Please upload the attached as an amended plan for A/146/19/PL.

Please find attached an amended drawing containing the changes that you have requested – (1) removing the rear projection so that the entire garden depth is 8.5m, (2) removing the rear dormer window to Bedroom 1 replaced with 2no. roof-lights at 1.5m height in order to ensure no possibility of overlooking, and (3) and very modestly enlarging the front elevation in line with your comment.

Proposed Bungalow
Plans and Elevations

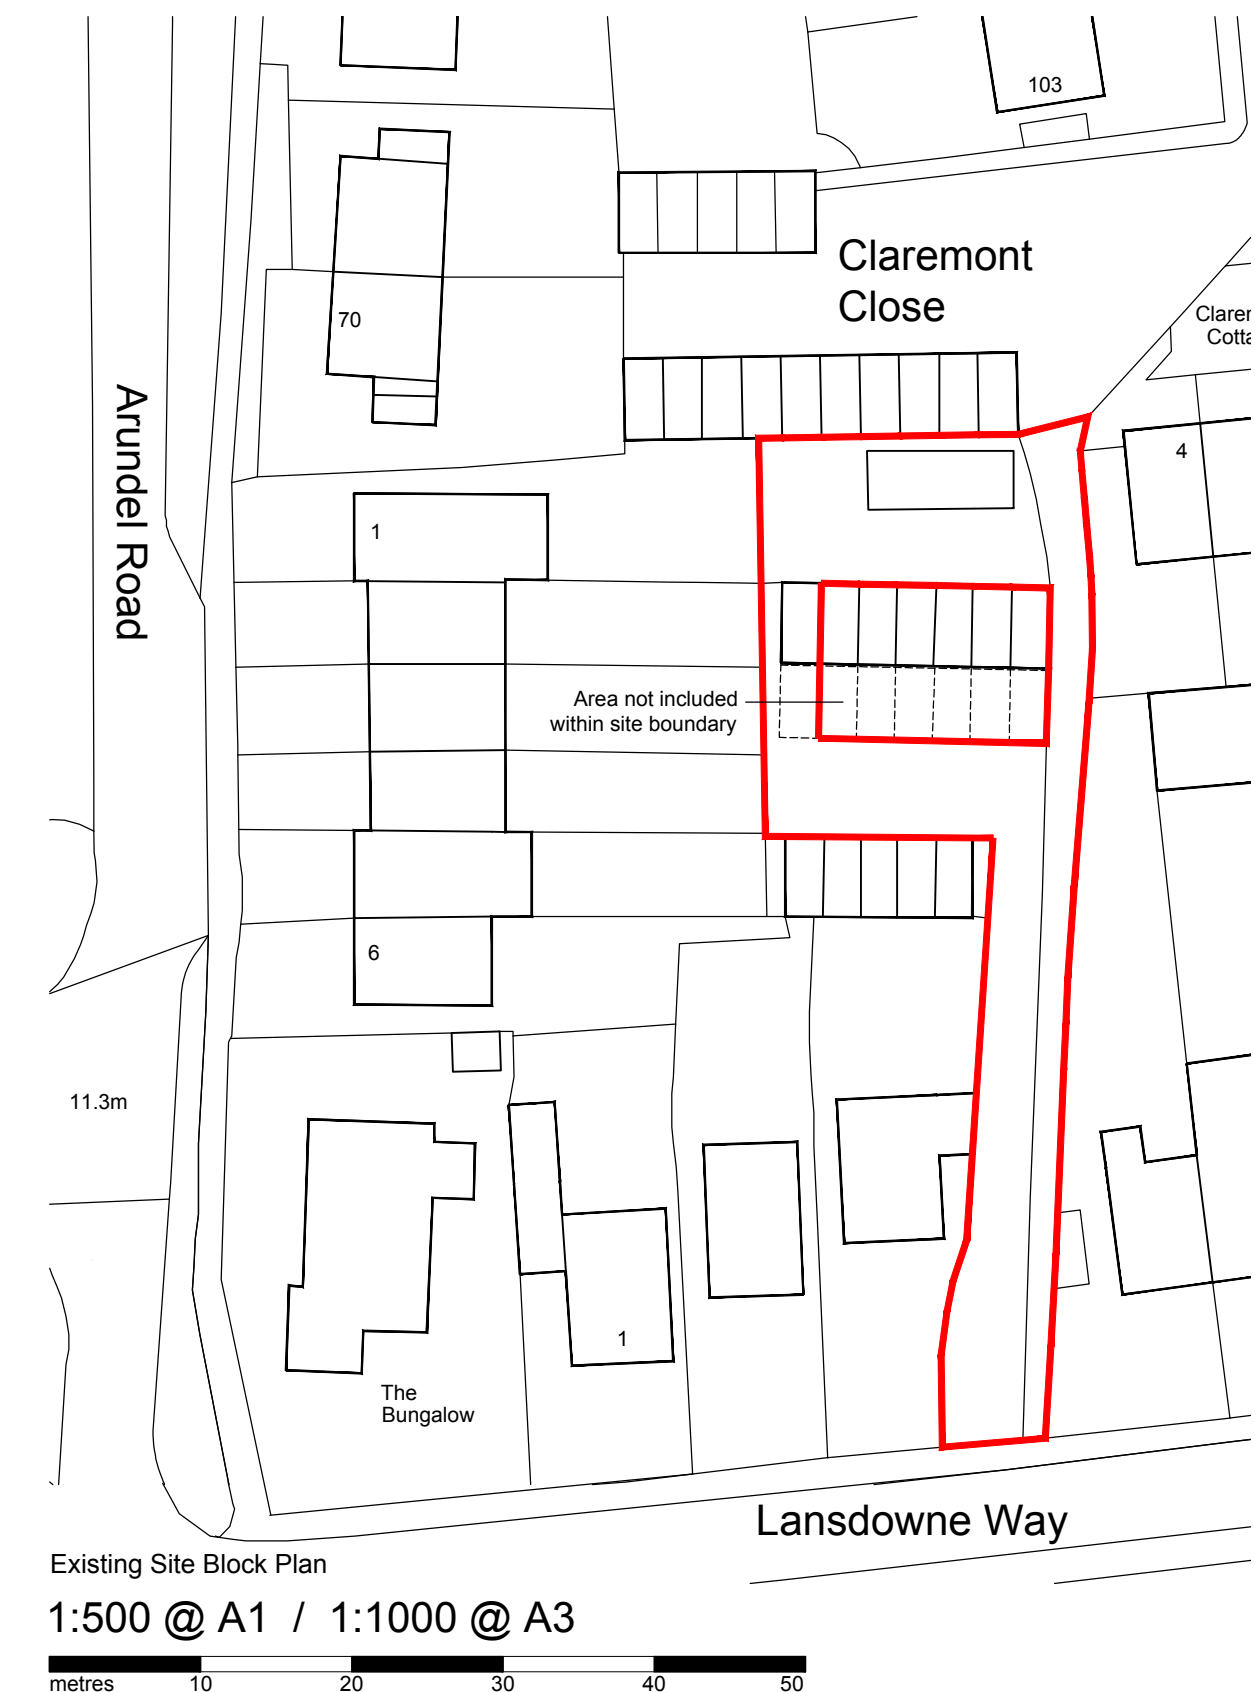
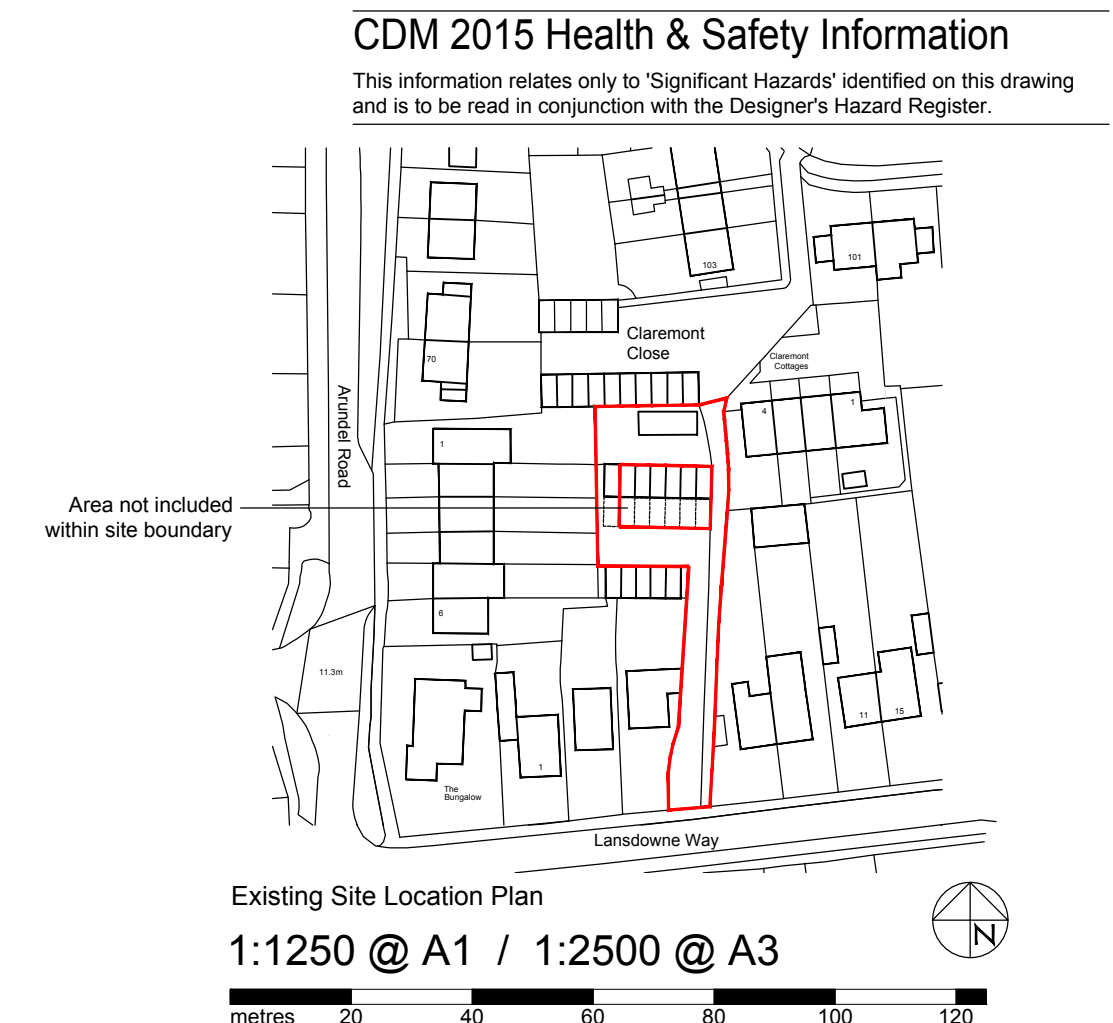
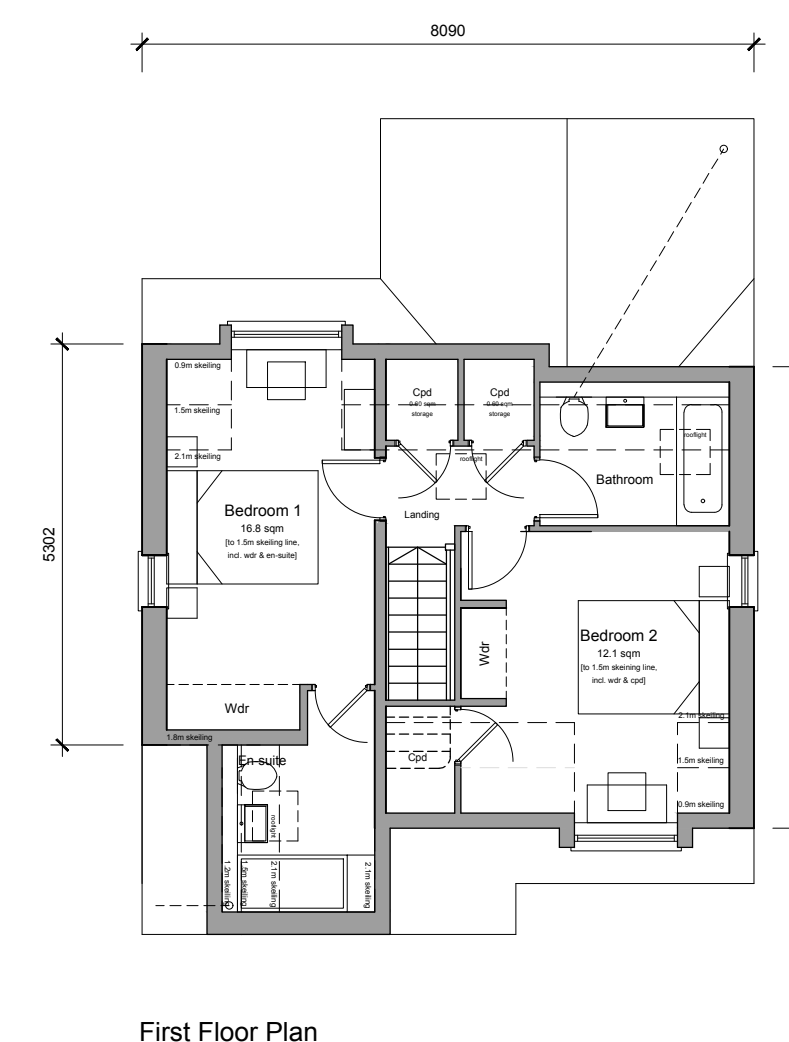
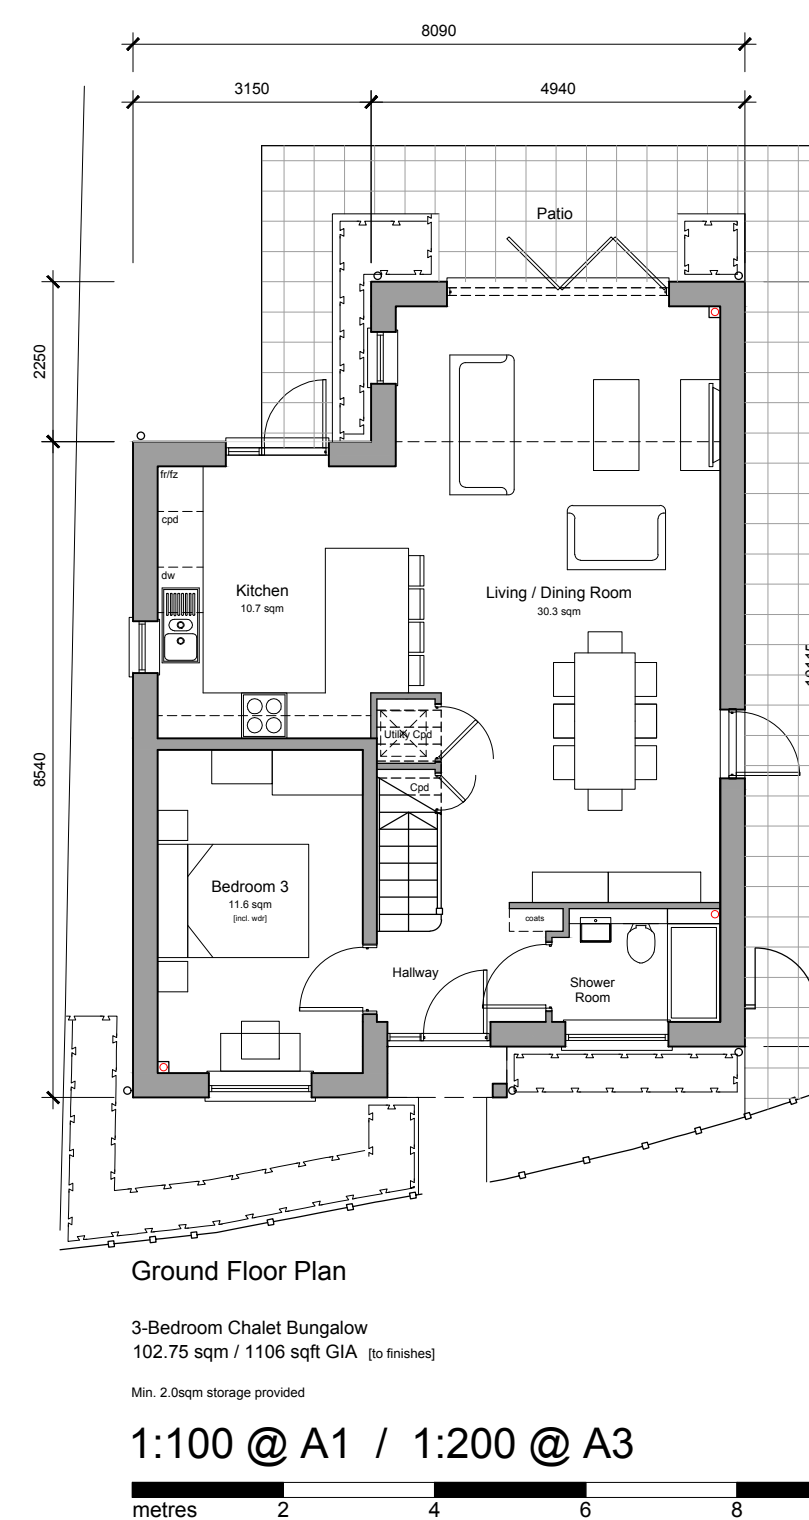
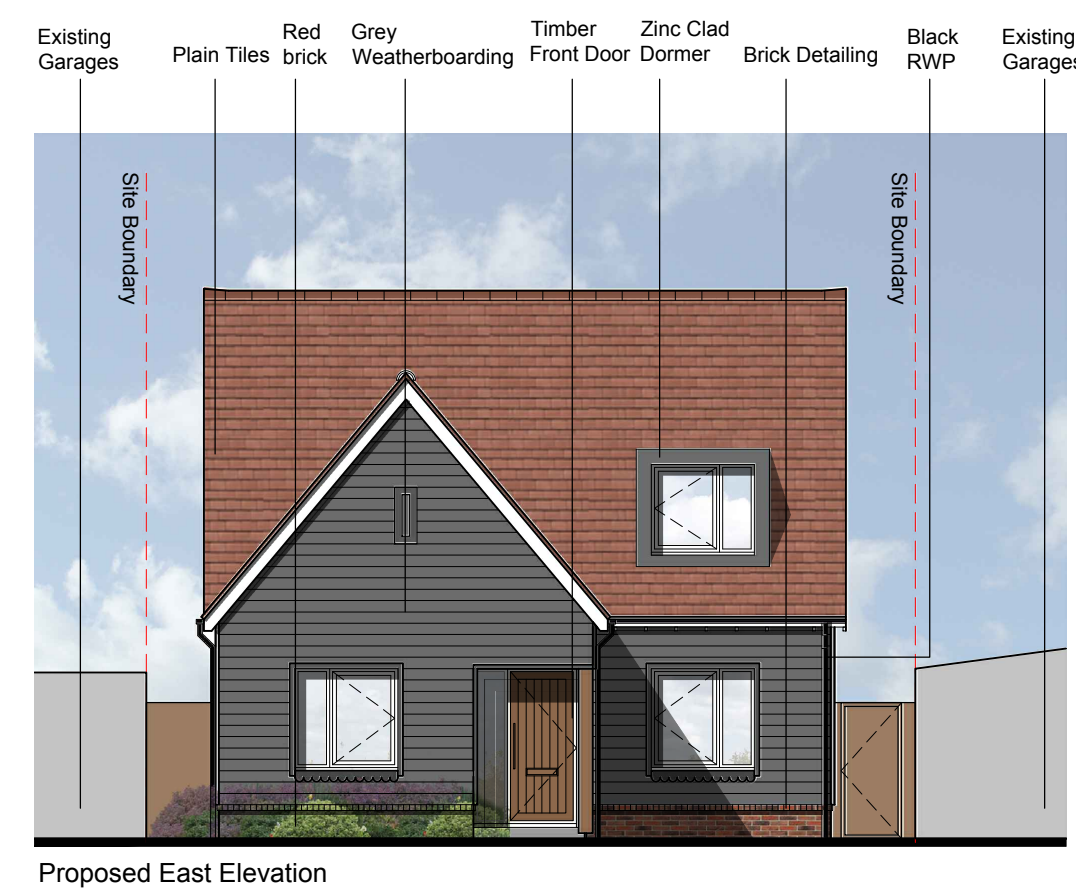
I had a chat here internally and we feel the proposal could be ok, on balance once a few changes are made. I mentioned your willingness to make whatever changes we felt necessary to get it over the line. Could you send in an amended plan removing the rear dormer (replacing it with a rooflight) and squaring off the rear elevation so that the rear garden depth would now be 8.5? If you wish you could slightly enlarge the dwelling at the front elevation to get back some internal space.

A rear garden of 8.5m in depth at maximum and 6.3m for the majority is less than what's recommended. As I'm sure you know 10 or 11m is looked at as a minimum depth. Although the principle of development is ok other issues such as above and the hemmed in nature of the proposal in relation to the rows of garages on either side are likely to be other issues for this proposal. I will have a closer look at 'Red Admiral Bungalows' and if possible visit this site when on site next week.

Your suggestion and willingness to make further amendments to the proposal in terms of the rear gable end and rear facing dormer window are also noted. However before I ask you to make any amendments I would like to carry out that site visit to see if this is what's needed to bring the proposal to a positive conclusion.
